Application Correspondence

From: [REDACTED]
Sent: 21 December 2017 17:16
To: Simon Davis
Subject: 36 Corbishley Rd

Site Plan: Scale 1:200

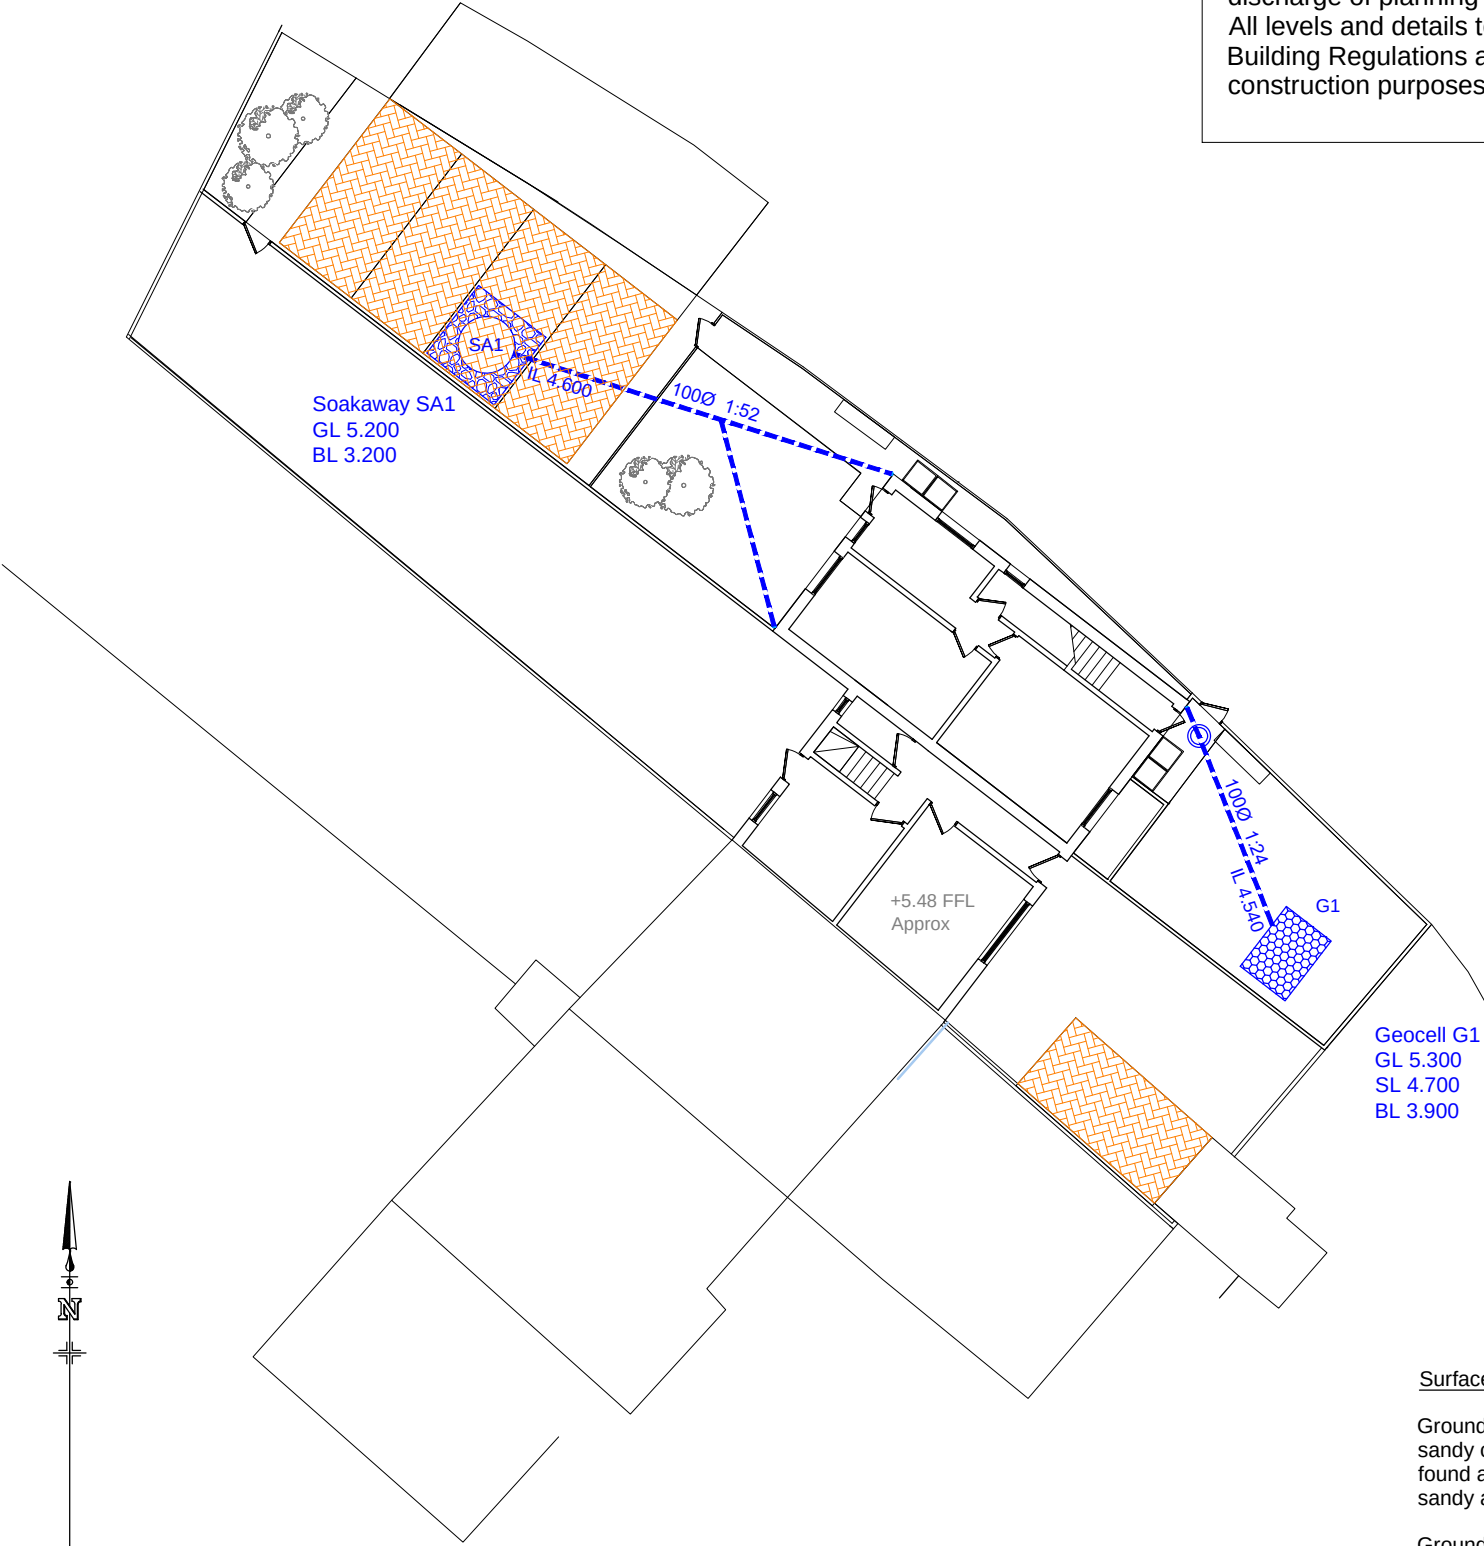
1. Provide silt trap manhole upstream of PCC ring soakaway.

We do not normally add silt trap manholes upstream of concrete ring soakaways as the soakaways themselves act as silt traps and can be cleaned out either manually or by tanker. The calculations do not include for soakage to occur through the base – only the sides for this reason.

Typical Permeable Paving
Scale 1:20

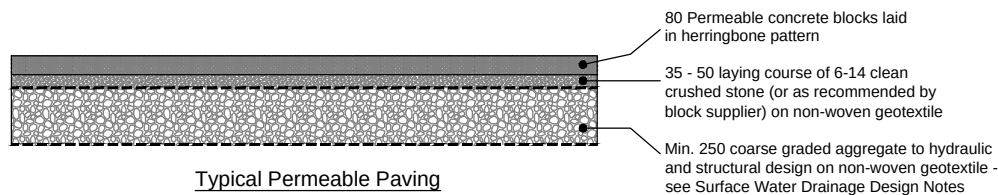
2. Provide construction detail to show how permeable pavement construction interacts with PCC ring soakaway.

3. Provide construction detail/calculations for the standalone section of permeable pavement.

The concrete ring soakaway is not designed to interact with the permeable paving in this case as it can deal with the flow on its own without the assistance of the permeable paving.

The standalone permeable paving just needs to deal with rainfall that lands on it – it is not required to accept flow from other impermeable areas and as such, is an improvement on original soft landscaped areas.
